Comment for planning application 20/00841/F

Application Number	20/00841/F
Location	Barn And Land South West Of Cotefield Farm Church Street Bodicote
Proposal	Erection of garage adjacent to approved dwelling and change of use of agricultural land to residential use
Case Officer	Bob Neville
Organisation Name	Corinne Hill
Address	Gaydon Fields Farm, Gaydon, Warwickshire, CV35 0HF
Type of Comment	Objection
Type	neighbour
Comments	<p>Buildings are not in keeping with the rural landscape and, without substantial screen planting, they will be highly visible from the village and footpaths. The size, siting and design of the 5 garages are considered an unnecessary and excessive development for a residential property even allowing for the storage of grounds maintenance equipment. We believe this development would cause an unjustified visual intrusion into the valued rural landscape and open countryside. We understand this application is contrary to the provisions and aims of saved Policy C28 of the CLP 1996, Policies ESD 10, ESD 13 and ESD 15 of the CLP 2031 and Government guidance within the NPPF in respect of conserving and enhancing the natural environment.</p>

Planning application:	20/

DRAWING NUMBER:  
**4728/22F**

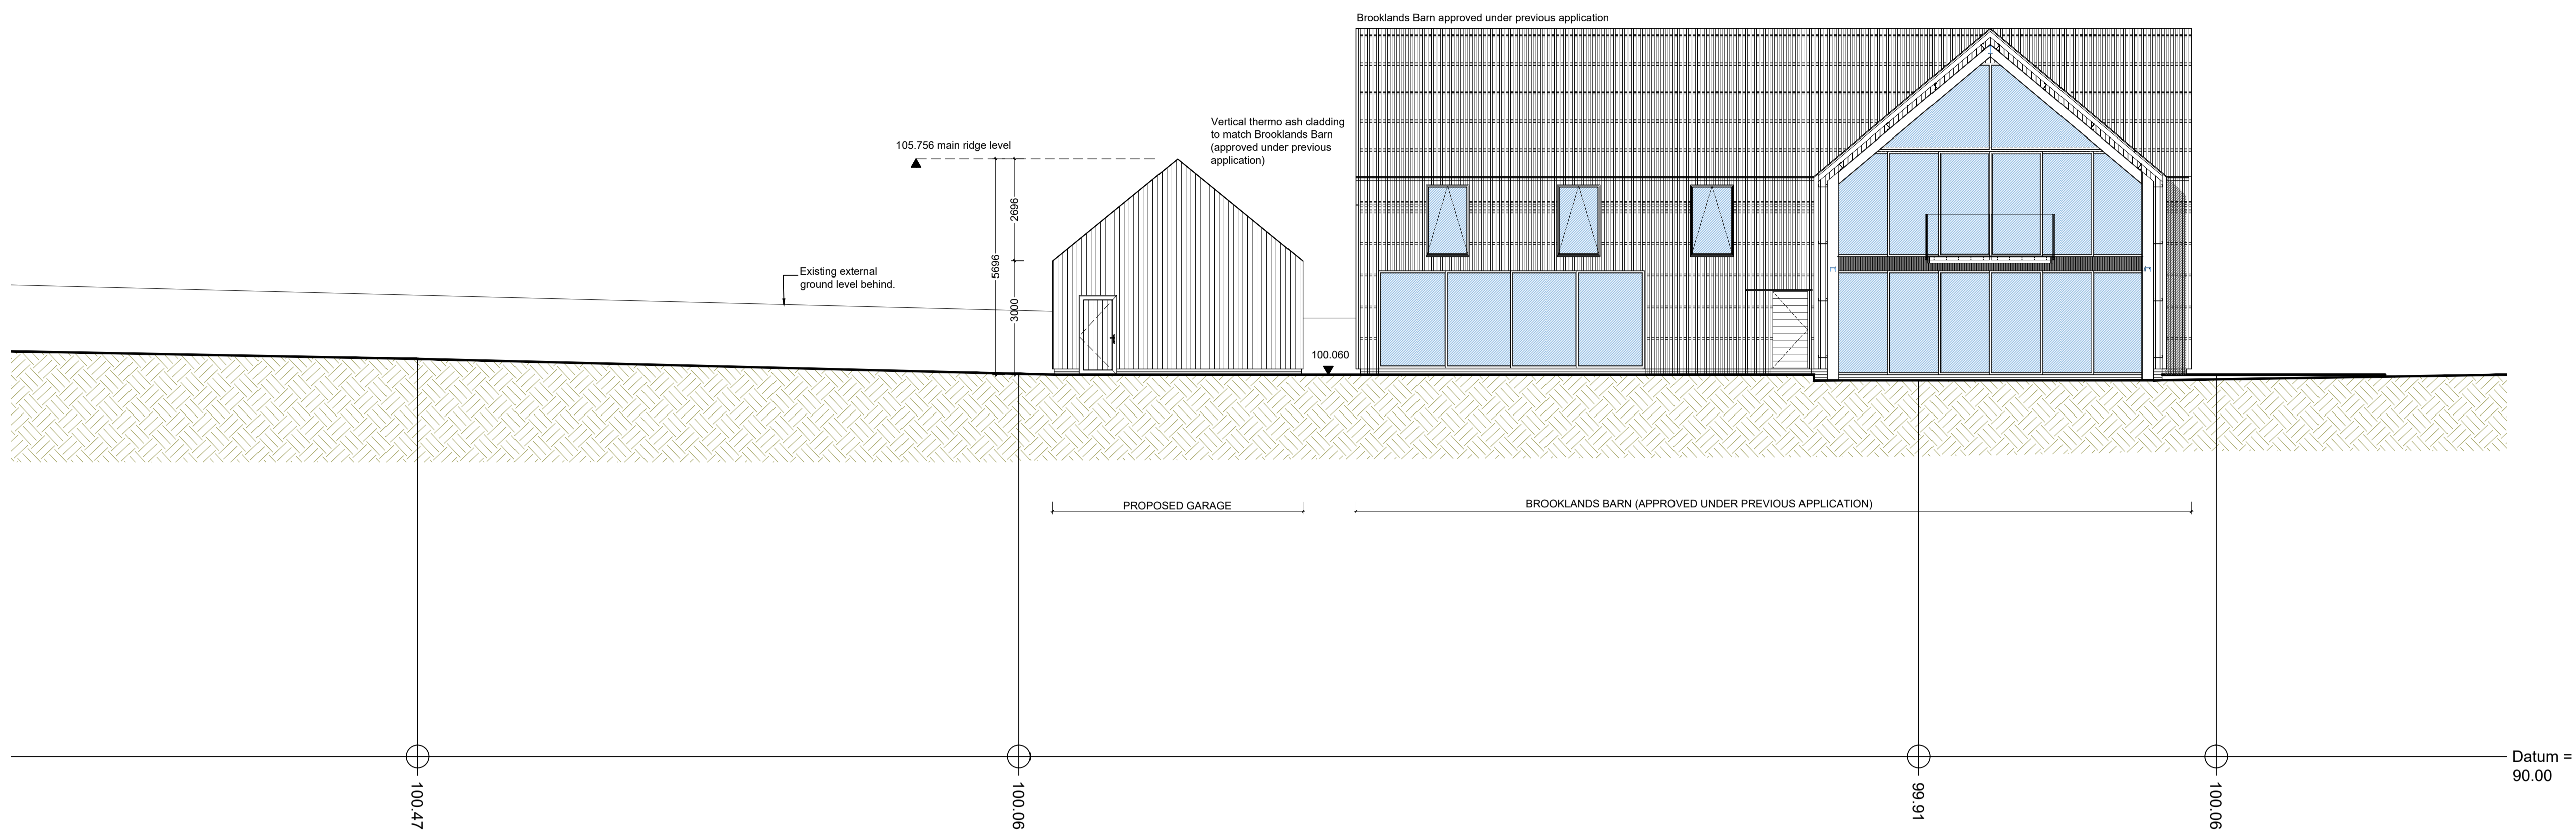
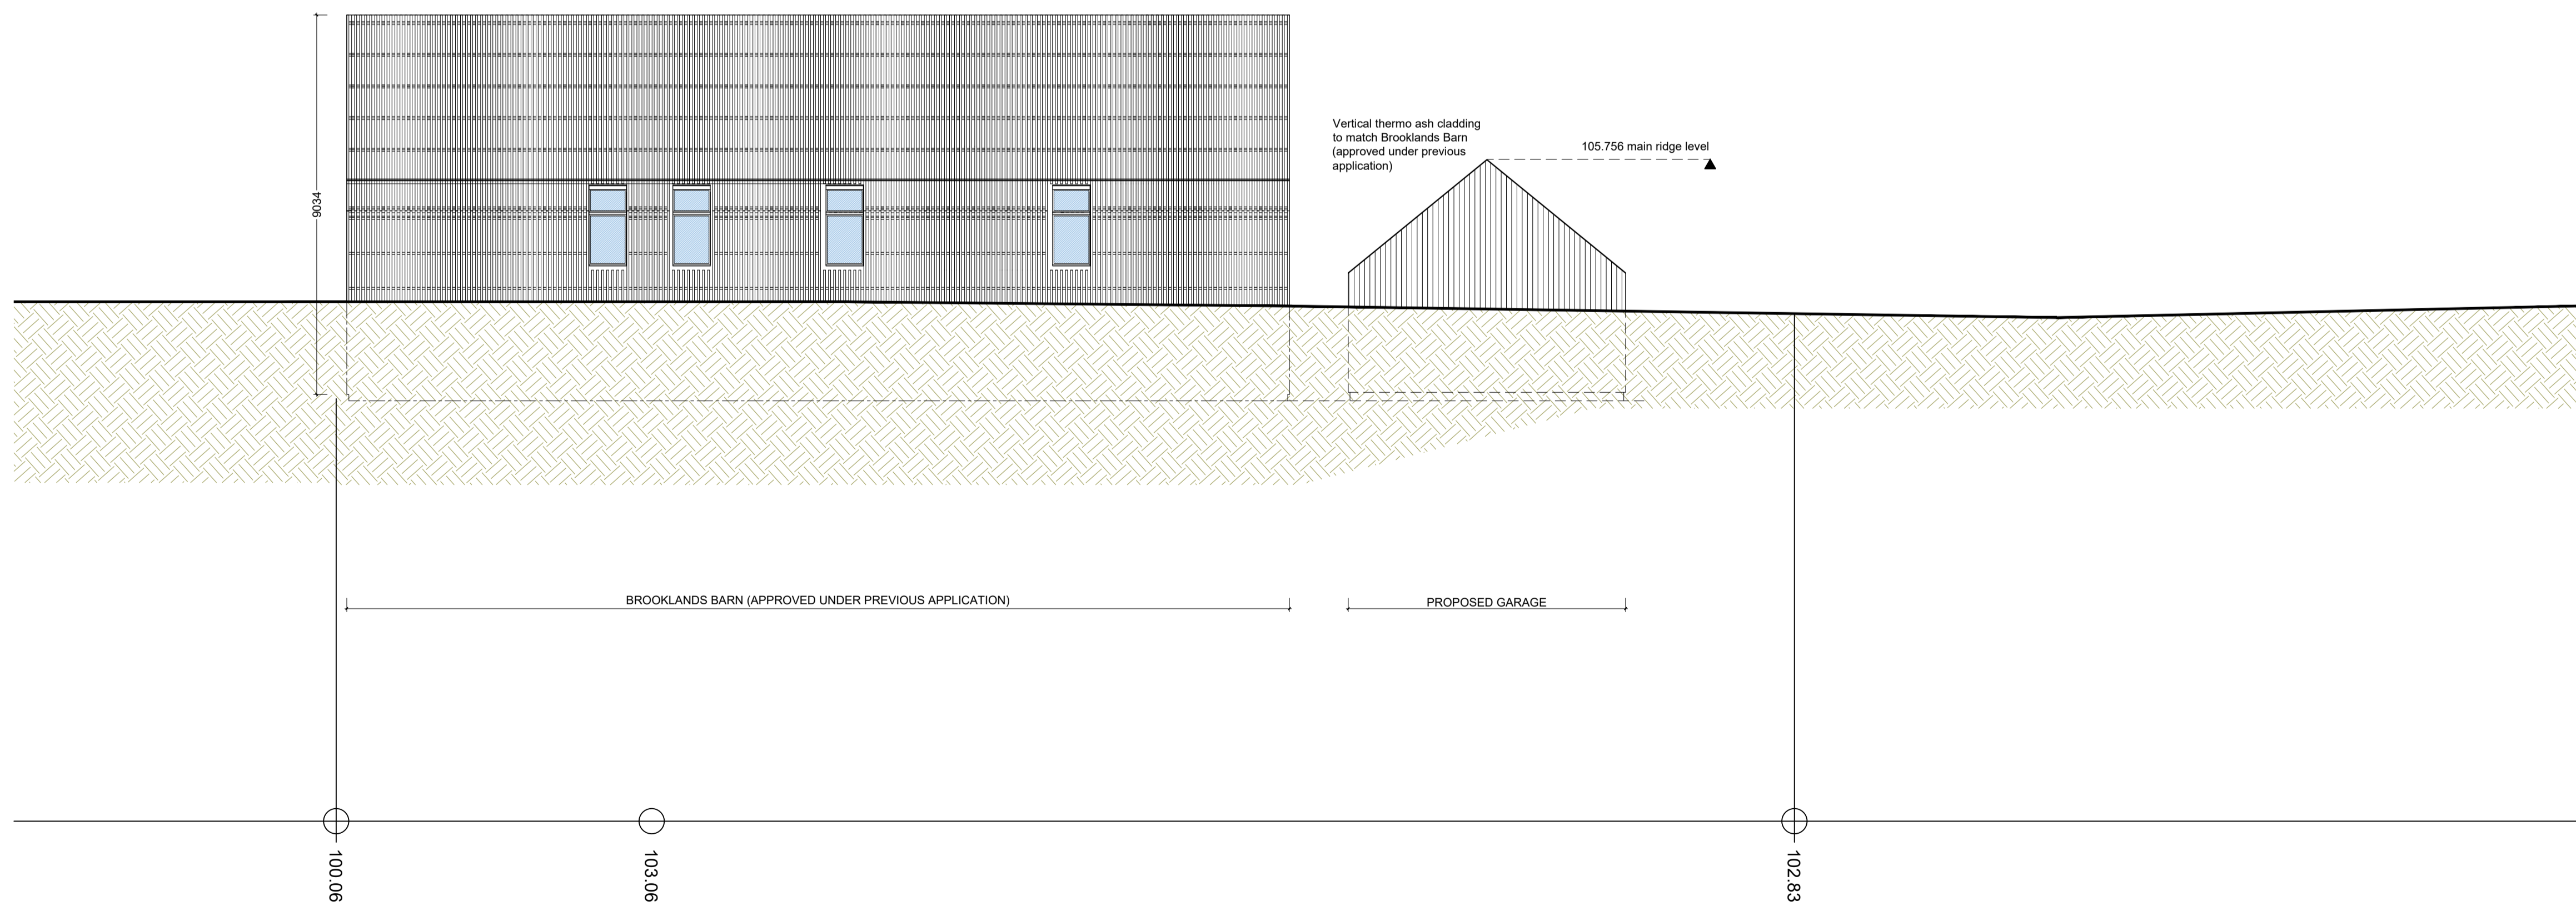
Having considered the landscape and visual appraisal my concern is for the localised visual harm to visual receptors using the Church Street/Public byway 136/20, looking over the fieldgate (near Viewpoint 1). The current proposed location of the garage outside the geometric alignment of the barn conversion means that it is quite visually prominent from this location. If the garage could be re-aligned with the east/west orientated part of the building this would enable screening of the garage behind the 2 existing trees. A new hedgerow should be planted give provide both privacy, and landscape mitigation.

The minimal difference in footprint being that the garage will be 4 m further away from the gable end but remain on the same east/west alignment. As I say if the garage is actually aligned with the garble end that would be visually more acceptable.
